DECISION DELEGATED TO DEVELOPMENT MANAGER

Application No: H13-0847-20 **Applicant:** Mr J Hook
Proposal: Erection of 2 detached dwellings
Location: Rear Of 46 Seas End Road Moulton Seas End Spalding
Terminal Date: 24th December 2020

FRONT ELEVATION - PLOT TWO

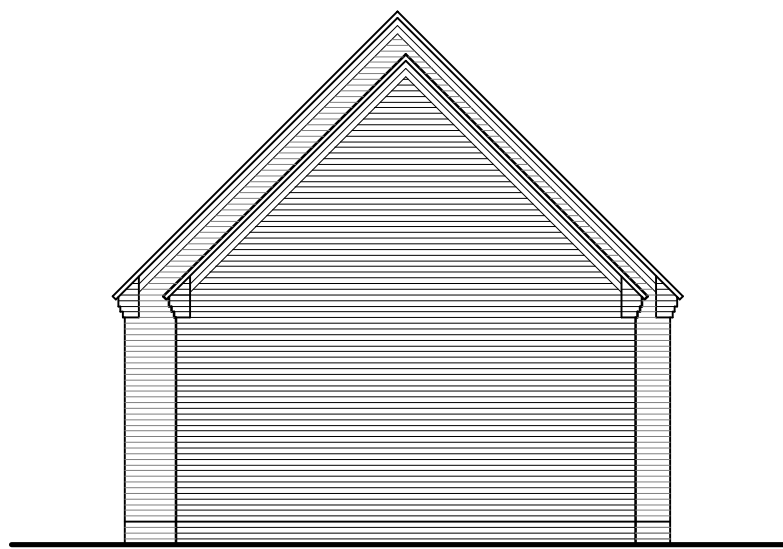
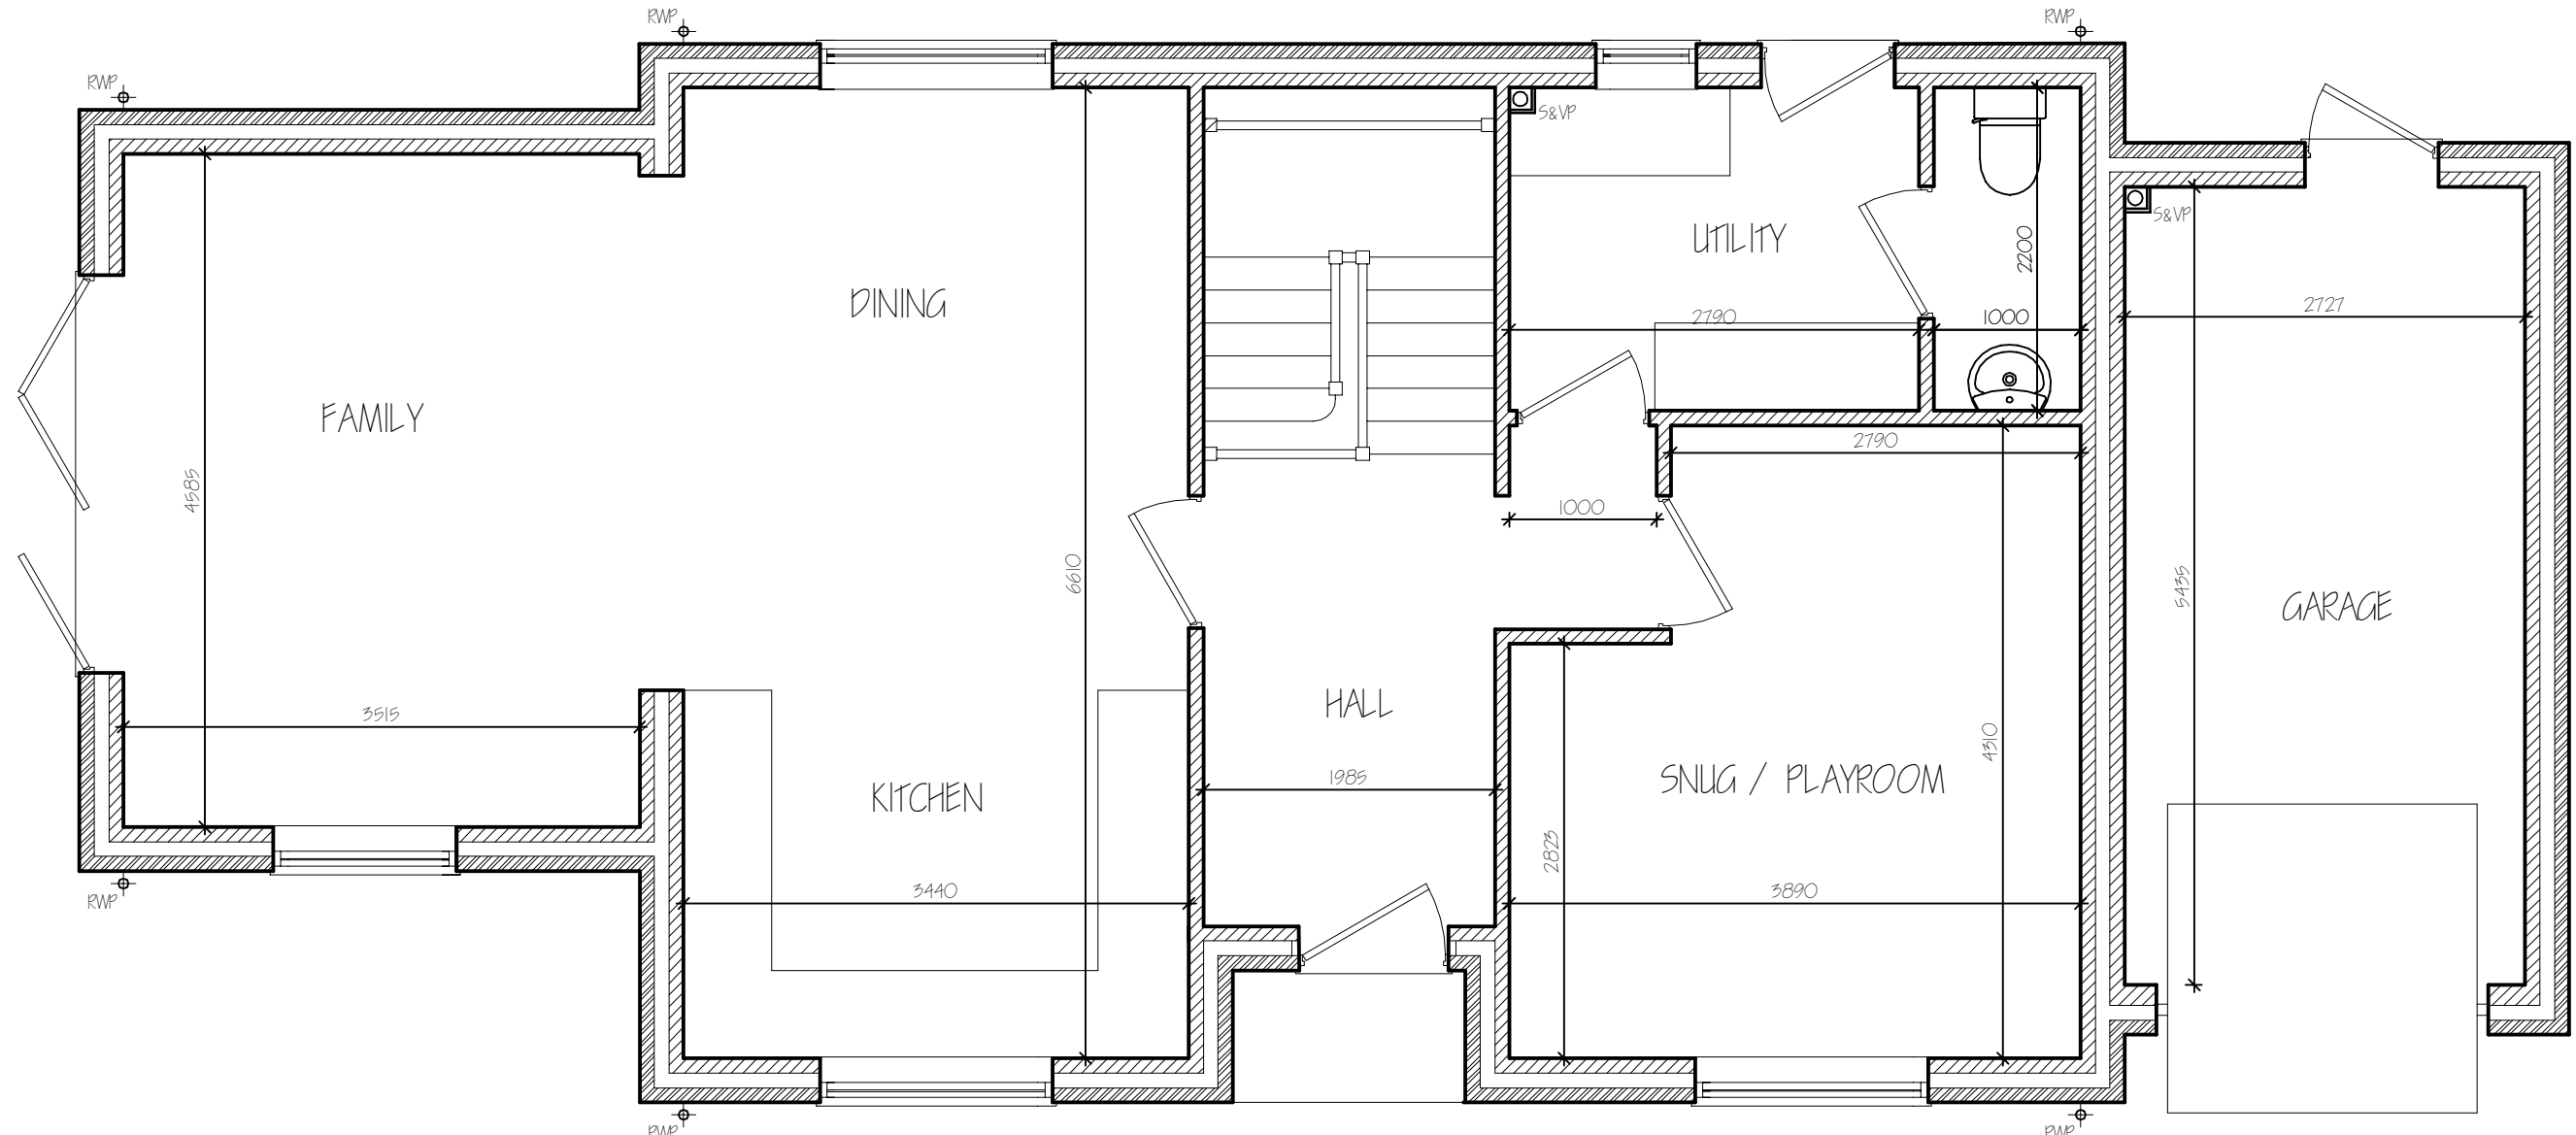
It is noted that a condition was imposed on the outline permission restricting the development to single storey with no rooms in the roof space. Overall, it is considered that the site is best suited to two modest sized bungalows that more closely reflect the indicative layout submitted at outline stage.

Taking the above into account, the scale of the proposed dwellings is considered to be inappropriate to this location and would negatively impact upon the character of the area. The proposal is therefore contrary to Policies 2 and 3 of the Local Plan. Policy 2 of the Local Plan requires development proposals to take into account sustainable development considerations such as: size, scale, layout, density, impact on character and appearance of the area and the relationship to existing development. Policy 3 requires development proposals to respect the density, scale and massing of neighbouring buildings and the landscape character of the location.

SITE PLAN 1:200

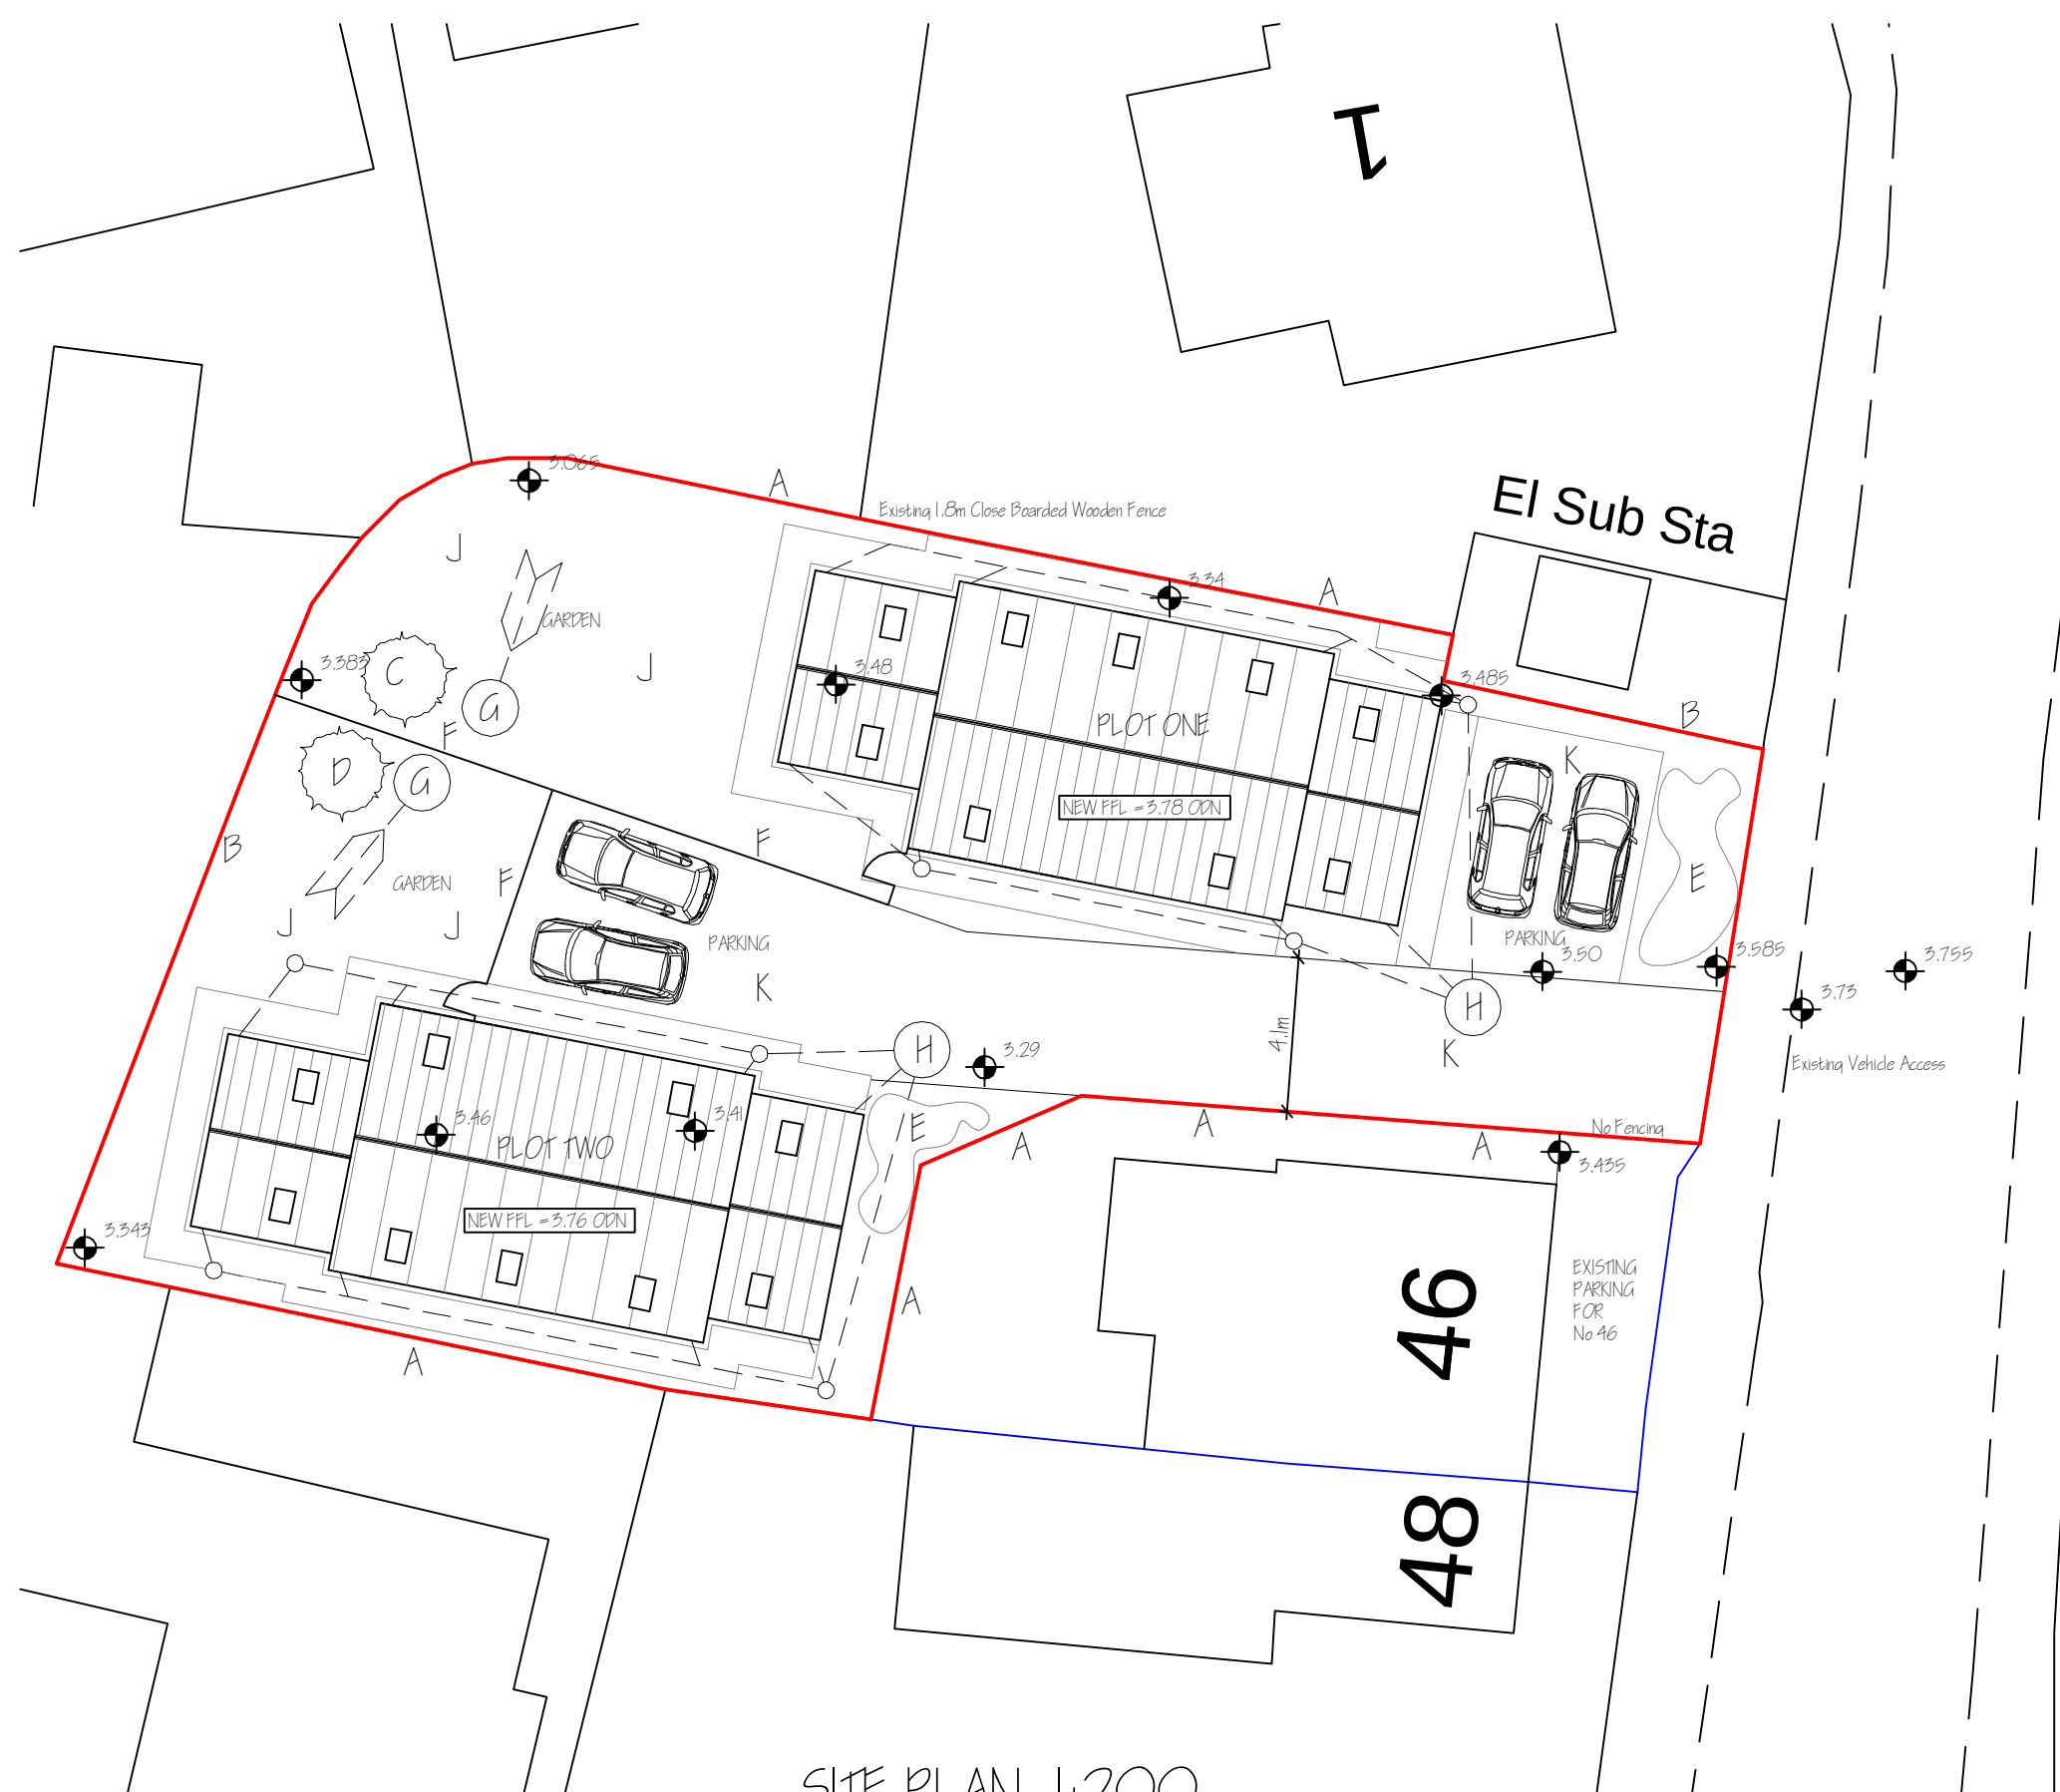
However, notwithstanding the above, it is considered that the scale of the proposed dwellings results in a form of development that is visually cramped and dominated by building, hardstanding and boundary treatments (at the rear). Plot 2 is particularly cramped, with minimal and seemingly unfunctional areas of external amenity space.

The rear elevation of Plot 2 ranges from approx. 7.5m to approx. 8.4m from the rear elevation of no. 6 Hall Lane. Although in planning terms there is no right to a view across neighbouring land, it is considered that at such a distance there will be a material adverse impact on the occupants outlook from the rear French doors to the lounge. This is a material planning concern and the applicant has declined to increase the separation distance to 10m.

Plots 1 and 2 are offset from one another meaning that an appropriate level of privacy will be afforded between ground floor windows. However, the rooflights at first floor to Plot 2 would face towards the lounge window of Plot 1 as well as its garden. There would therefore be an overlooking impact in this regard.

Although sufficient external amenity space would be provided for Plot 1, there is minimal and seemingly unfunctional areas of external amenity space for Plot 2.
